Blackpool Council - Development Management

Pre-application advice report

Reference: 20/0176

Proposal: Demolition of existing building and erection of six storey building to form a Cafe to ground floor and permanent flats to the upper floors.

FRONT ELEVATION (WEST)

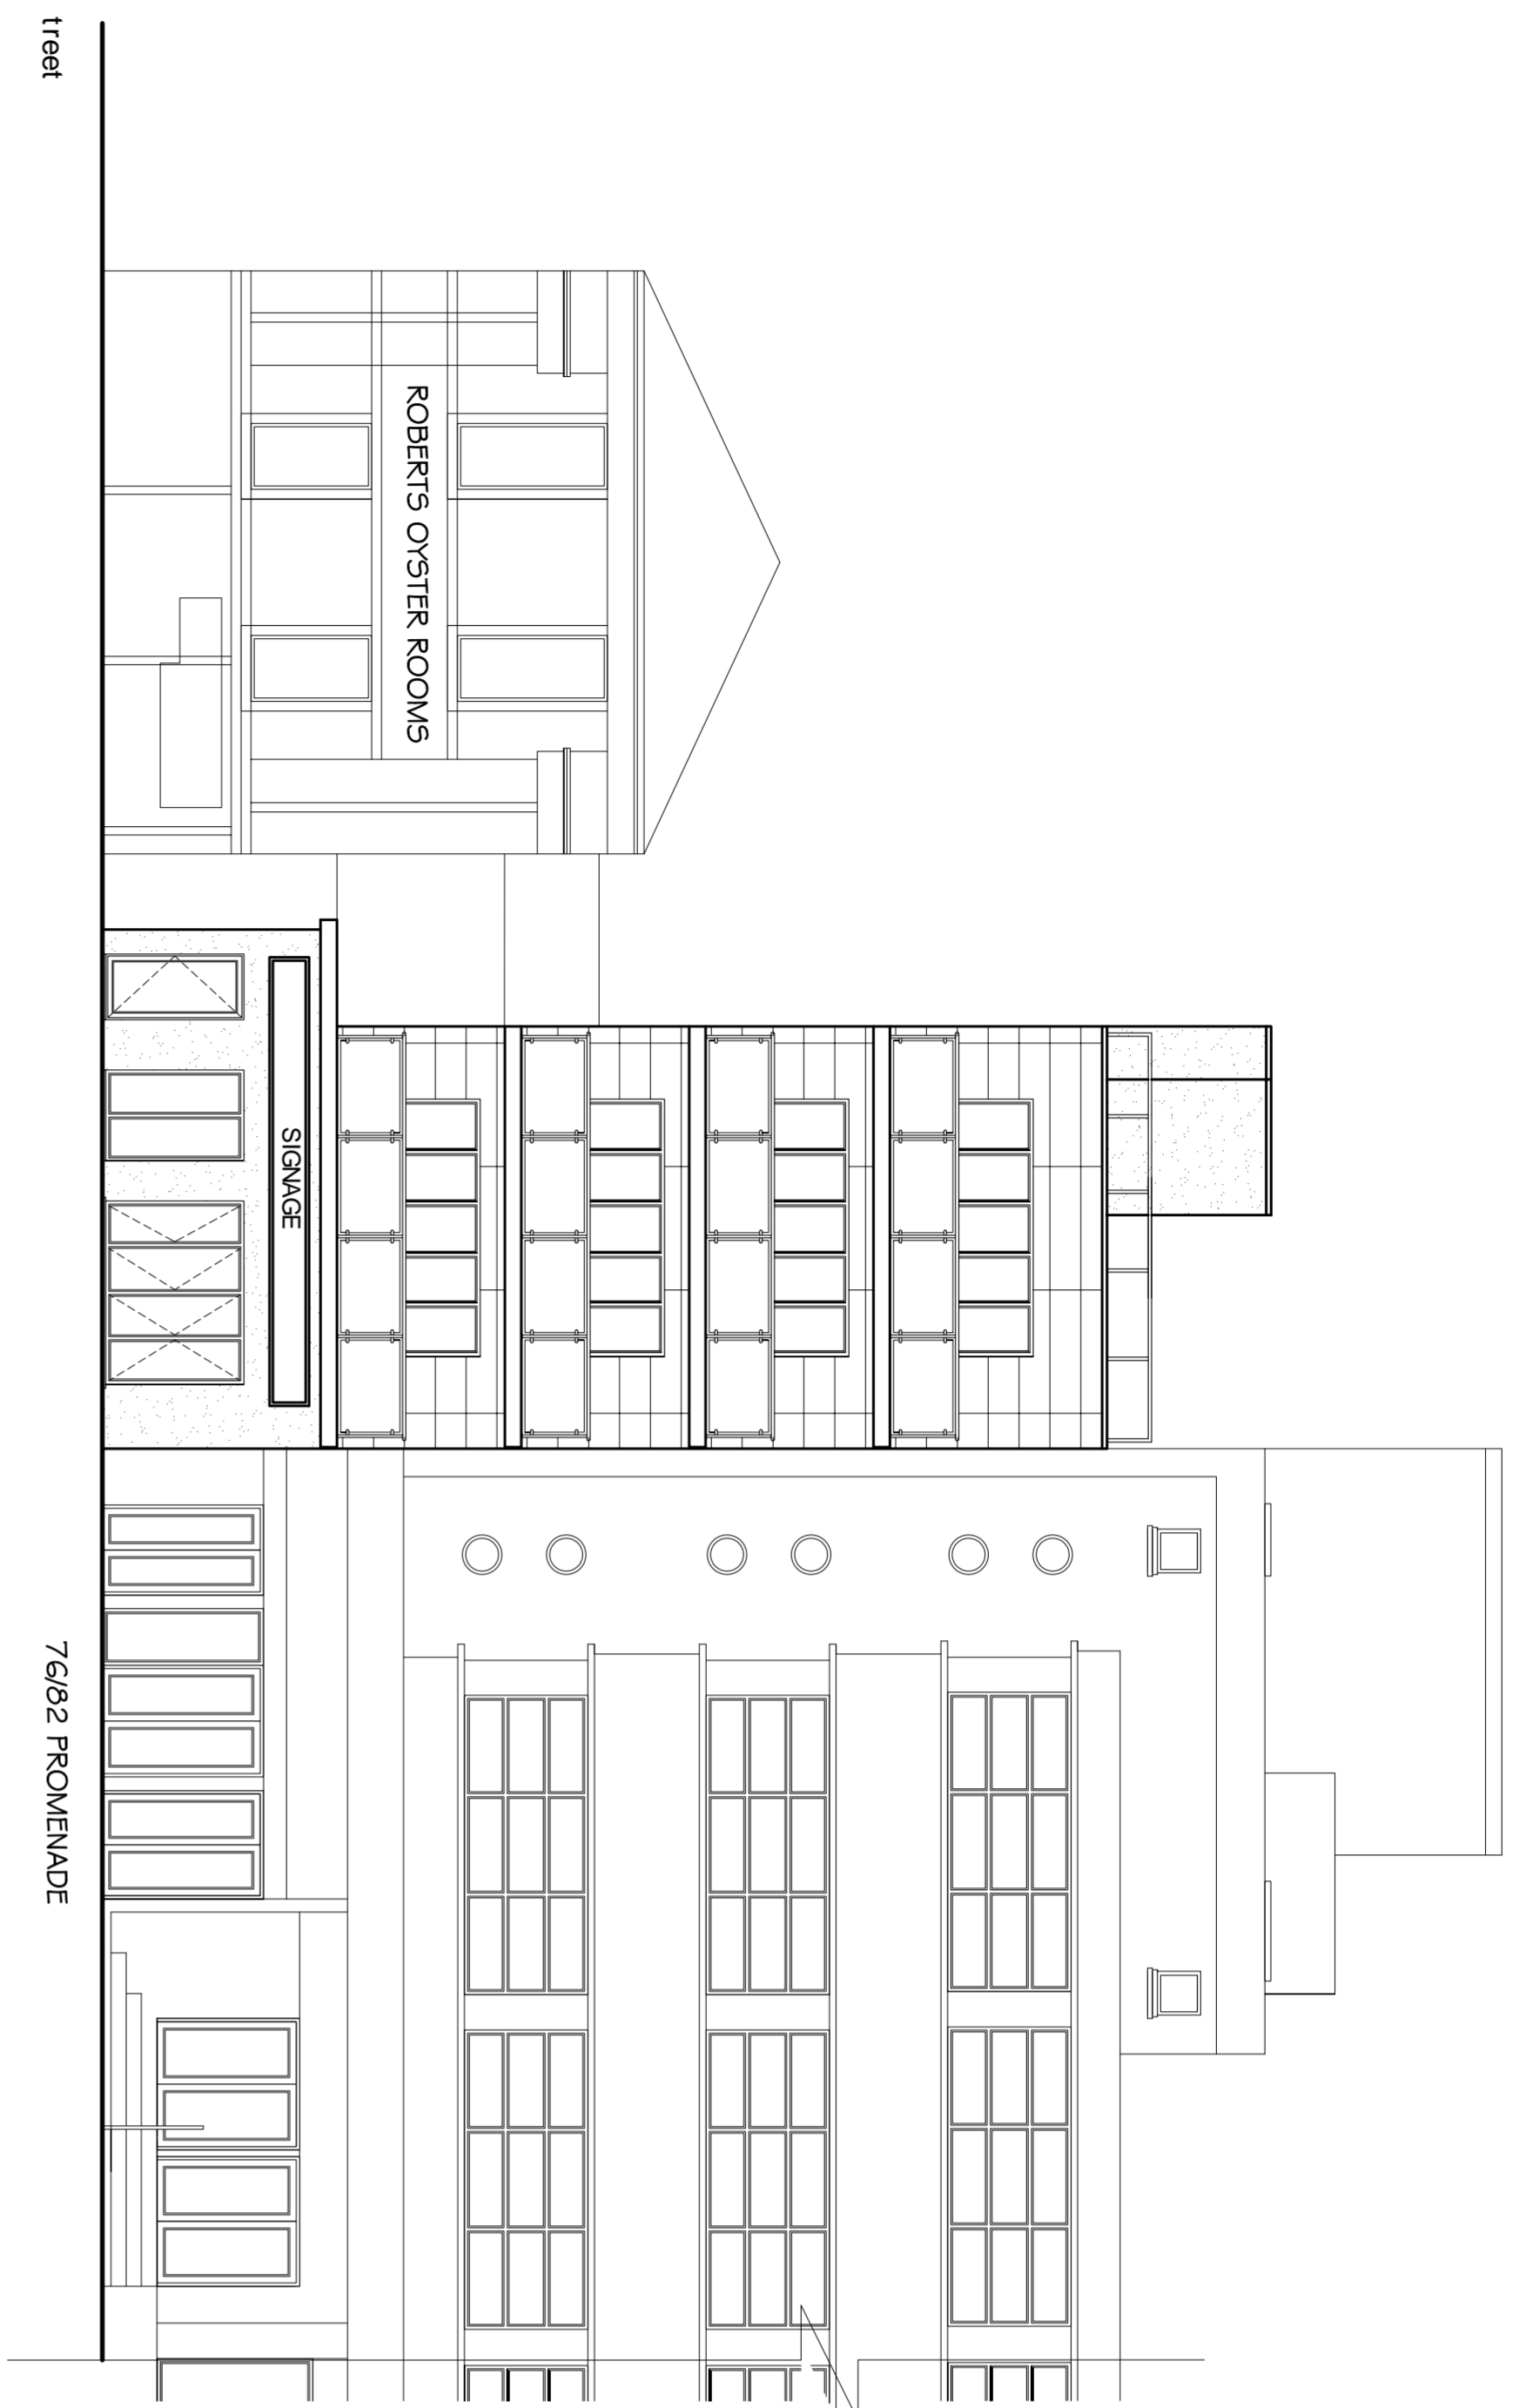
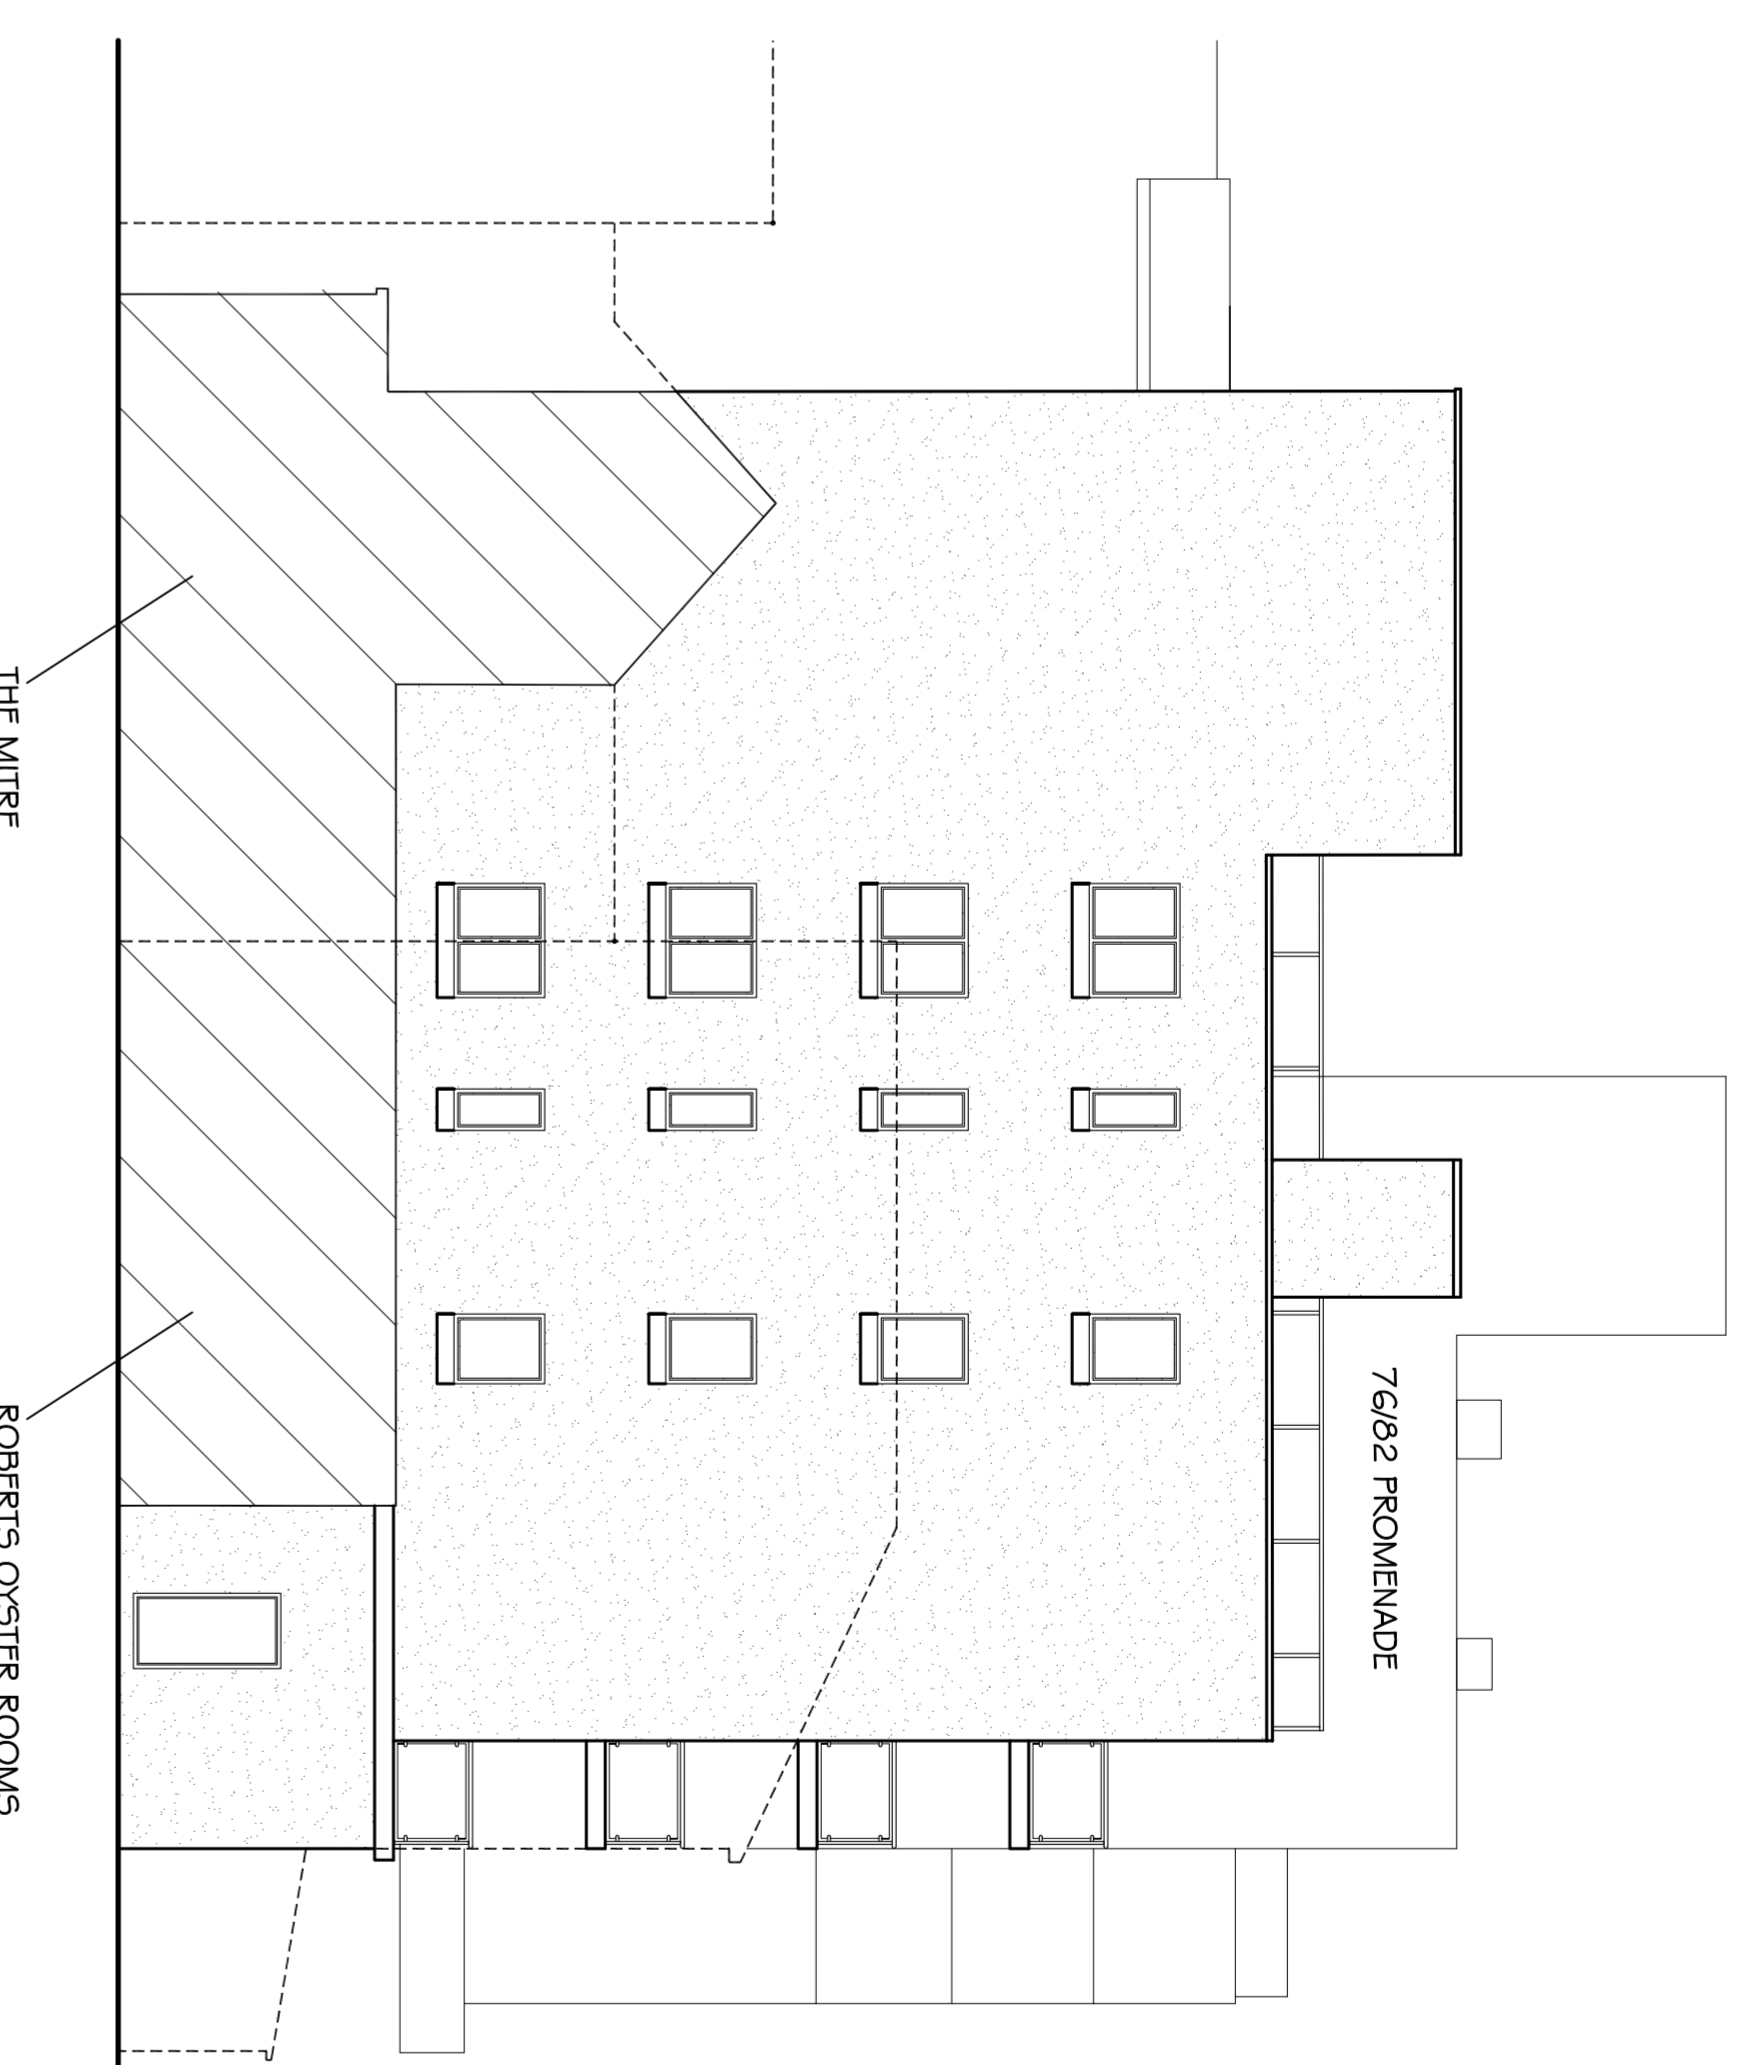
- 2.1 Erection of seven storey building (including a basement). To the side of the proposed building abutting Roberts Oyster Bar is a tiled lift shaft. There is a gap between the proposed building and Roberts Oyster Bar at upper floor levels with an attached single storey projection at ground floor level which contains the entrance to the flats. The building abuts the Superbowl building. The building projects forward of the Oyster Rooms but not forward of the Superbowl building. The bays on the Superbowl frontage are not accurately reflected in the north elevation, neither is the canopy. Also, the canopy on the Oyster Rooms projects much further forward than the Superbowl building, this relationship is not shown accurately on the elevational drawings.

- 2.2 The building proposes a café and toilets on the ground floor, with kitchen, cellar store, bottle and bin store and plant room in the basement. The upper floors comprise a two bedroomed permanent flat on each floor i.e. five flats in total, each with a Promenade facing balcony and with an open roof terrace above. The south side elevation does not correlate with the north elevation and the east elevation appears to show the gap between the proposed site and the Oyster Bar closed up.

to the adjoining Superbowl building, however the roof terrace would require a larger wind break than shown and that in itself would have a visual/adverse impact on the height and scale of the building. Any new building should step down in height from the Superbowl building to the surrounding, locally listed buildings to better fit within the context. Detailed approval of facing materials would be dealt with via an appropriate condition.

5.3.2 The main front elevation of the proposed building lies behind the Superbowl frontage, as do the balconies. The three storey height Roberts Oyster Bar projects forward to the same level as the main front elevation of the Superbowl. Roberts Oyster bar has a single storey canopy projecting further still. In terms of the position of the proposed building within the Promenade streetscene insufficient clarity has been provided to ensure that it would be acceptable.

5.3.3 The design takes its cues from the former Savoy café to the right. However, as stated, the height needs to be reduced so it steps up more gradually from Roberts Oyster Rooms by losing the top floor (so the roof terrace is lower down). It also makes permanent the current poor design which has brought forward the building line at street level. The proposed stairs to the upper floors from this area would mean the small infill next door to Roberts Oyster Rooms would become a permanent fixture, not only diminishing its individual character as one of the oldest buildings on the Promenade but also bringing forward the upper floors so they cover more of the side elevation of the Oyster Rooms. It would obscure some of the existing features of the building principally the name sign on the side elevation, which is part of the fabric of the building. Whilst the Oyster Bar is not statutorily listed it is nevertheless of local historic interest and the obscuring of the building detailing is not acceptable on this Locally Listed Building within the Conservation Area.

5.3.4 I would suggest that the infill/lobby for the stairs is removed to open up the gap between the Oyster Rooms and the new building. The building line for the whole building should be set back (so the café is flush with the upper floors and should not project forward of the adjacent Oyster Rooms) and the entrance for the flats should also be set back. The vents should be set further back within the site. The design would need to reflect the locality (i.e. art deco like the remainder of this block with appropriate materials). The ground floor infill detracts from the setting of the Oyster Rooms. This would be an opportunity to enhance it whilst mitigating the loss of a building which has some architectural merit. If the scheme is eventually approved then it should be recorded by the appropriate RIBA standard before demolition.
